MEMORANDUM

Re: Lorson Ranch East Fil. No. 4 As-Built deviation justification

This memorandum is to provide justification for deviating from final construction plans for several items related to construction within Lorson Ranch East Filing No. 4. This as-built deviation memo is in response to a Preliminary Acceptance Punchlist prepared by El Paso County DPW on January 11, 2024.

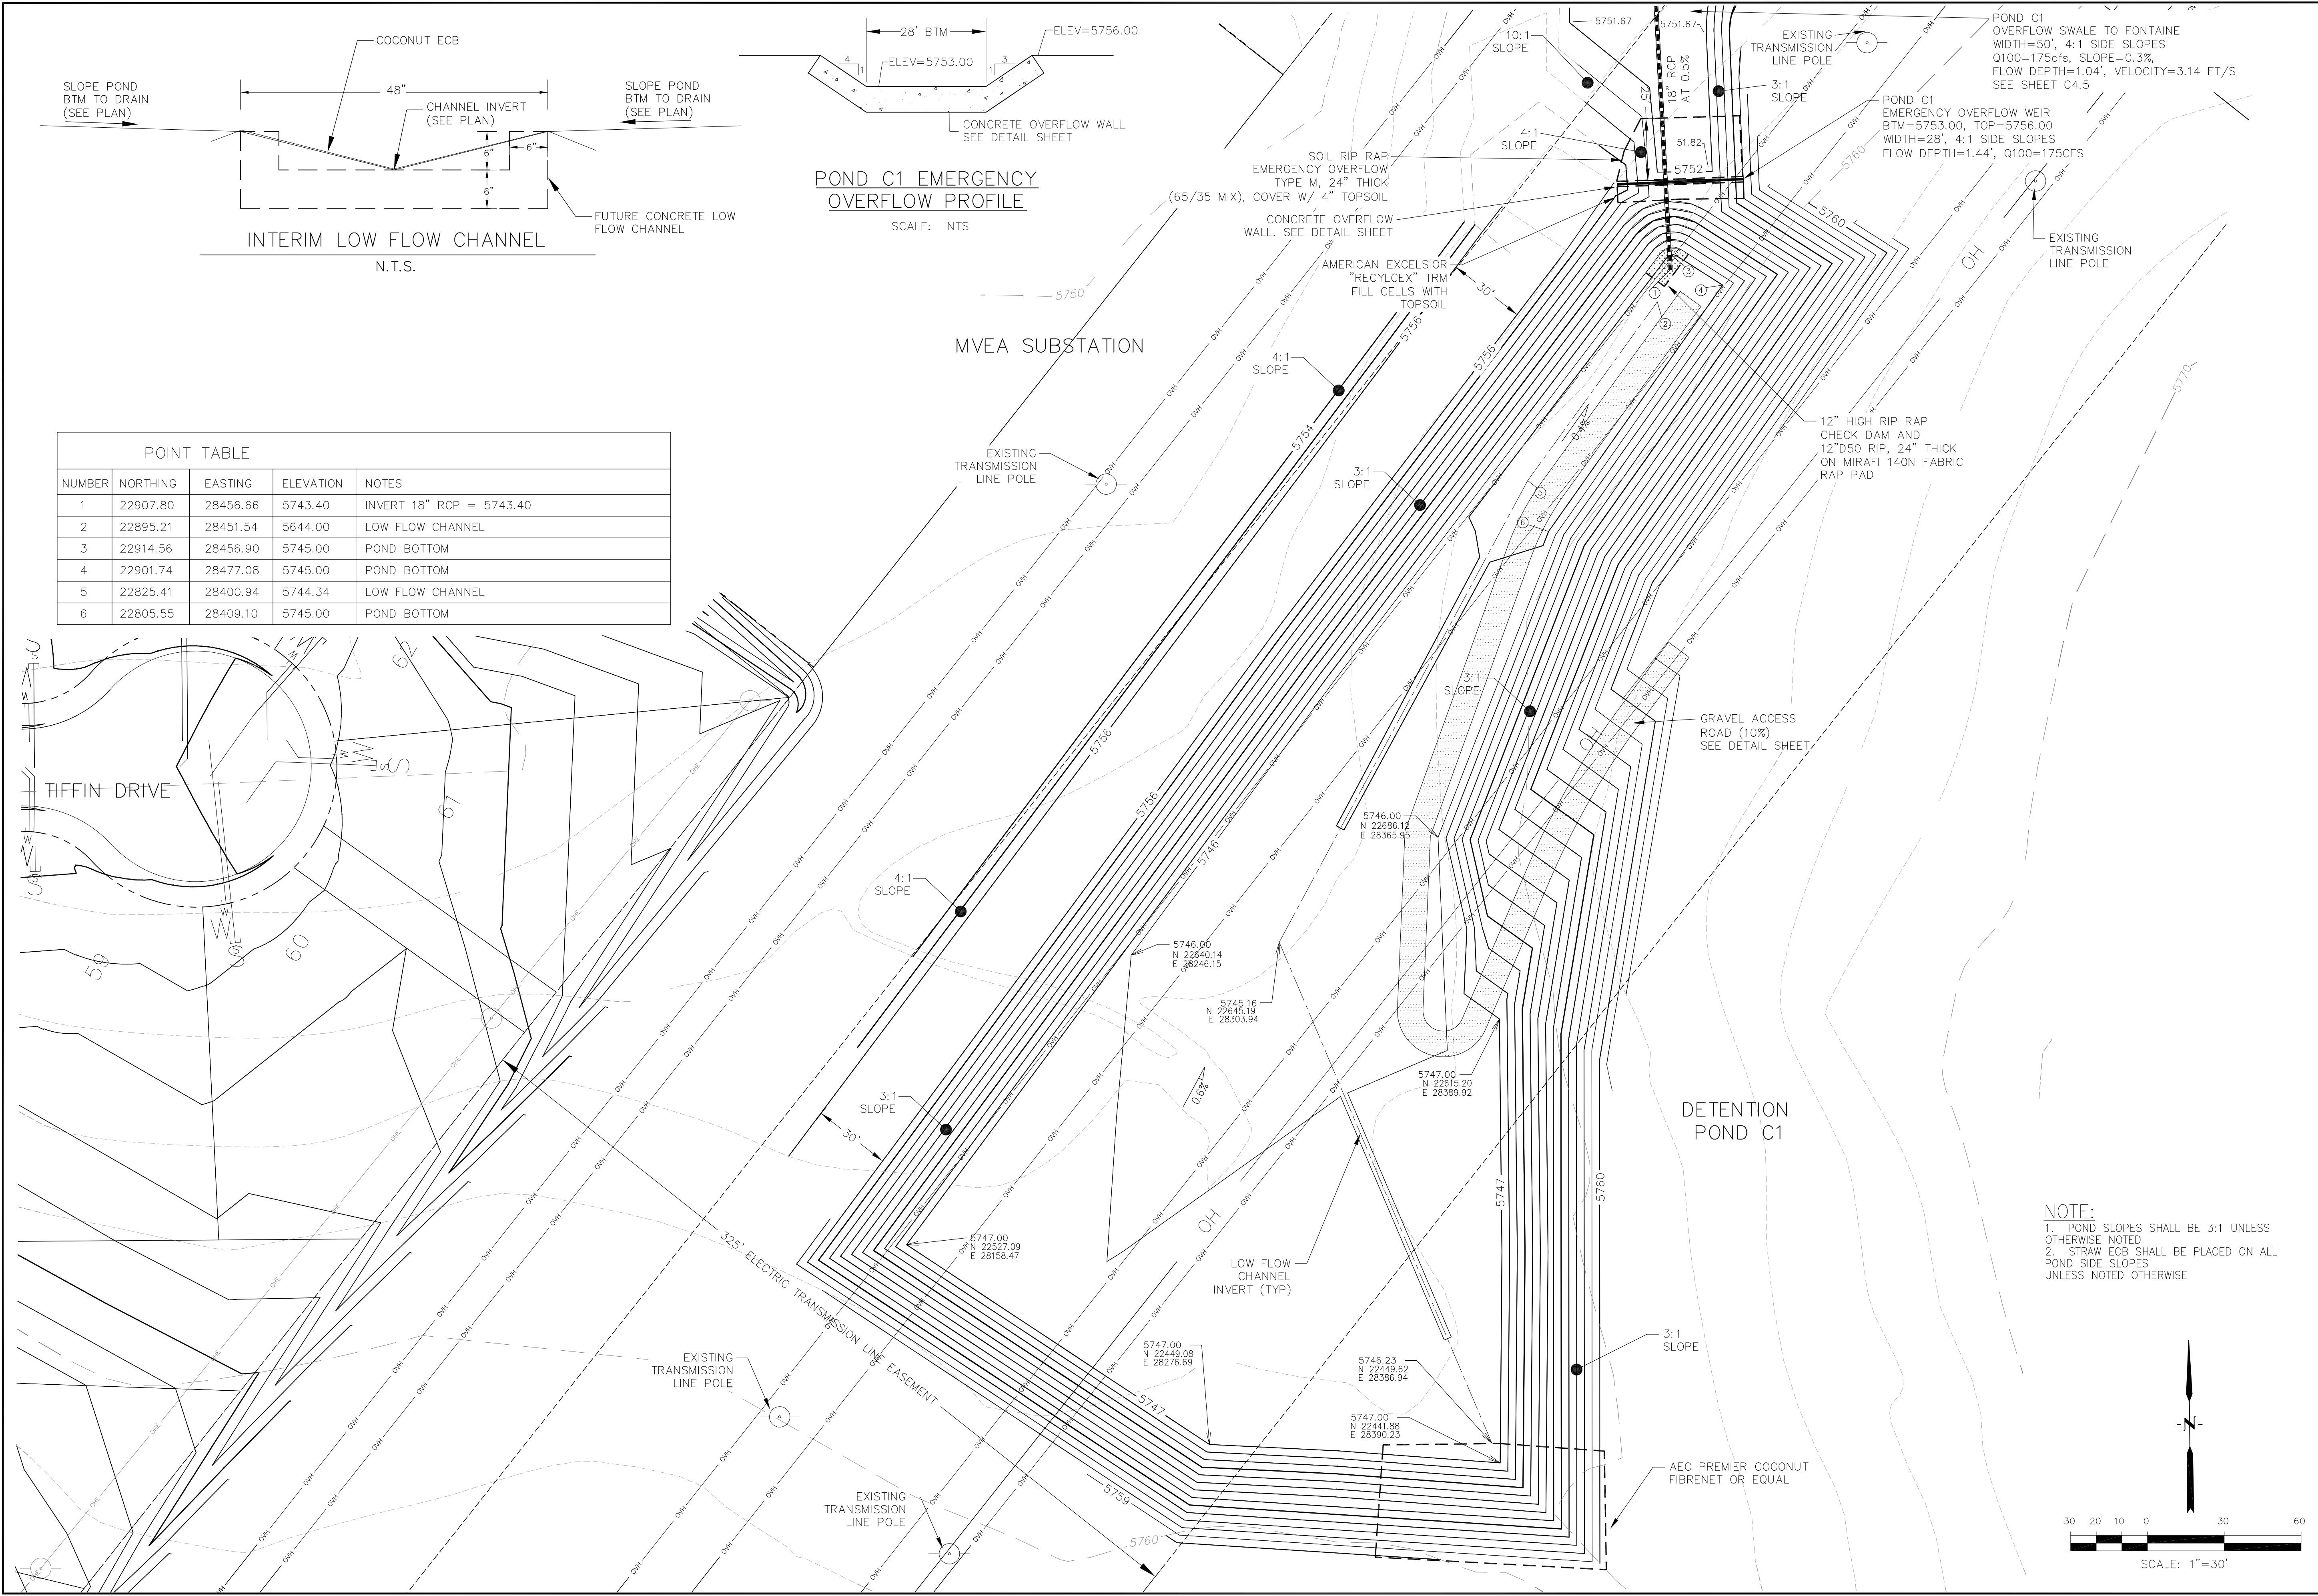
- Justify missing AEC perimeter coconut fibernet or equivalent along the east perimeter slope. Reference sheet C5.2 of the Final Grading and Erosion Control Plans.
- Justify missing Gravel Access Road. Reference sheet C5.2 of the Final Grading and Erosion Control Plans.
- Justify missing 12" high riprap check dam with fabric and riprap pad at outlet pipe. Reference sheet C5.2 of the Final Grading and Erosion Control Plans.
- Justify missing low flow channel. Reference sheet C5.2 of the Final Grading and Erosion Control Plans.
- Water retention within pond. Fill pond bottom to be at approved grade to allow for positive drainage.

1. Missing AEC coconut fibernet on east side: The fibernet was intended to prevent erosion on the east pond slope where concentrated flow might occur. Pond E1 has been constructed for several years and slope erosion does not appear to be an issue. Elimination of the fibernet is requested and the District will monitor the east pond slopes for erosion.

2. Missing gravel access road: This pond is not a permanent structure yet so a gravel access road is not necessary. The access road will be added to the Hillside at Lorson Ranch CD's (PUDSP 221)

3. Missing rip rap check dam: No checkdam is needed since pond bottom is lower than outlet pipe.
4. Missing low flow channel: The pond is currently acting as a TSB and thus a low flow channel is not necessary at this time. Construction of a low flow channel is included in the Hillside at Lorson Ranch CD's.

5. Water retention in Pond: When water accumulates in the pond it will be pumped out as part of the interim pond maintenance. Pond bottom will be filled as part of Hillside at Lorson Ranch.

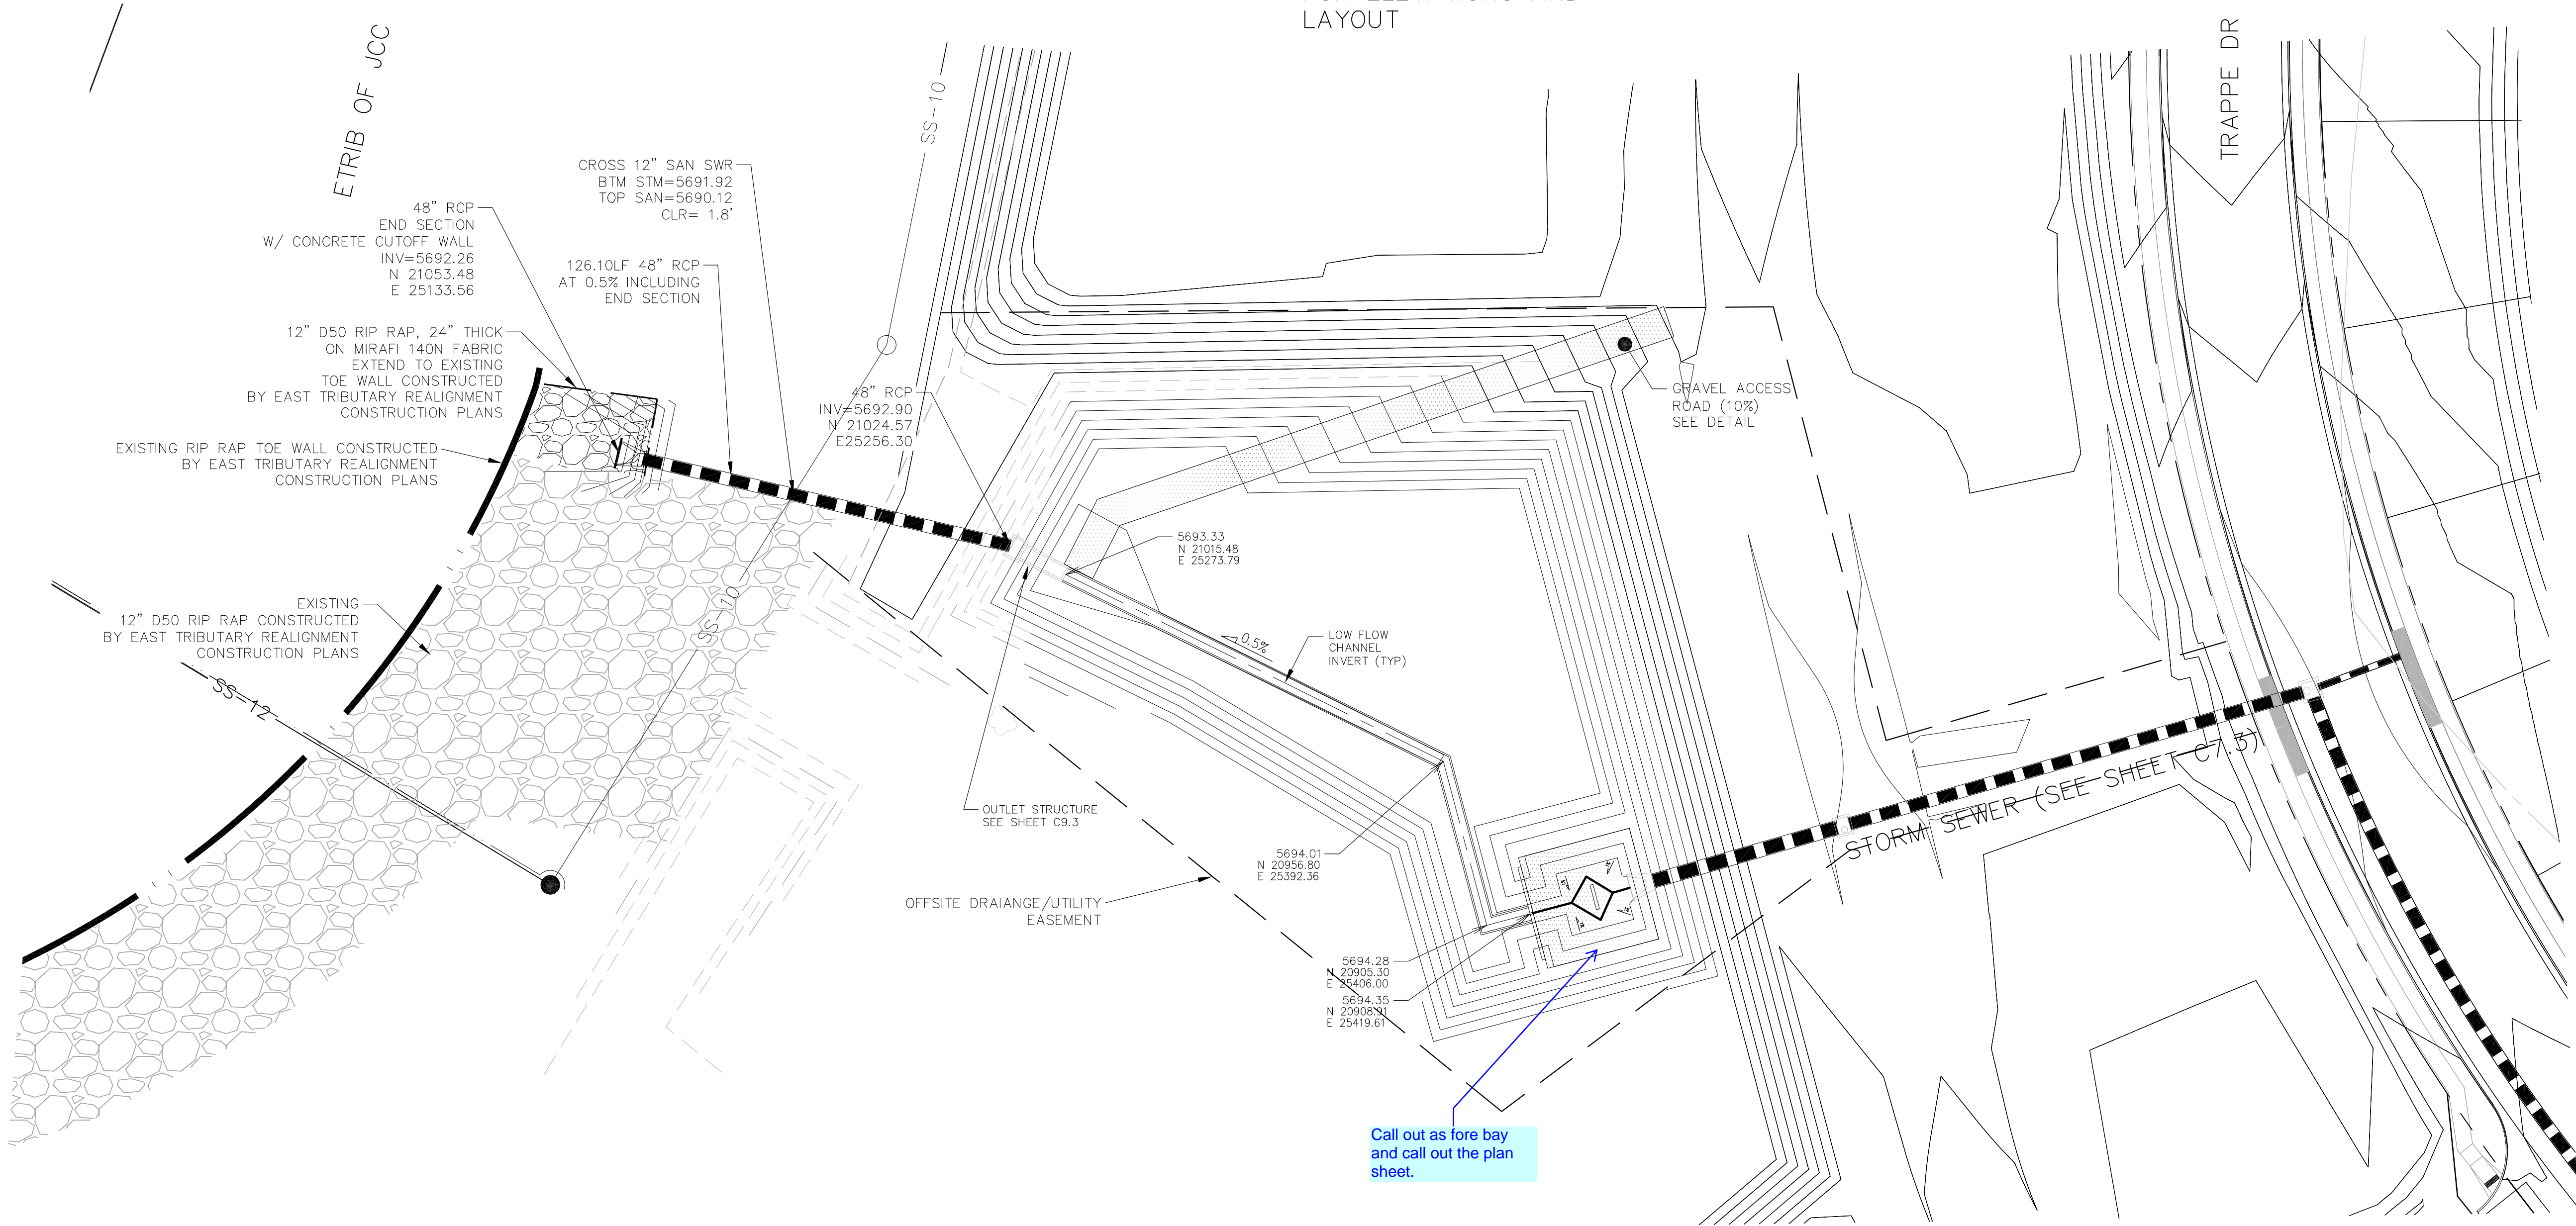
- ~~Confirm caulk bead around orifice plate.~~
- ~~Remove sediment and debris from outlet structure micropool.~~
- ~~Implement missing bolts on outlet structure top grates.~~
- ~~Confirm installation of 24" thick soil riprap at east forebay. Reference sheet C9.1 of the Construction Plans.~~
- ~~Remove excess sediment from maintenance access road within pond bottom and reestablish road base along trickle channel. Access road should consist of 12" thick class 6 aggregate. Reference sheet C9.1 of the Construction Plans.~~
- ~~Repair rilling along maintenance access road. Rilling could worsen and will be required to be repaired at Final Acceptance.~~
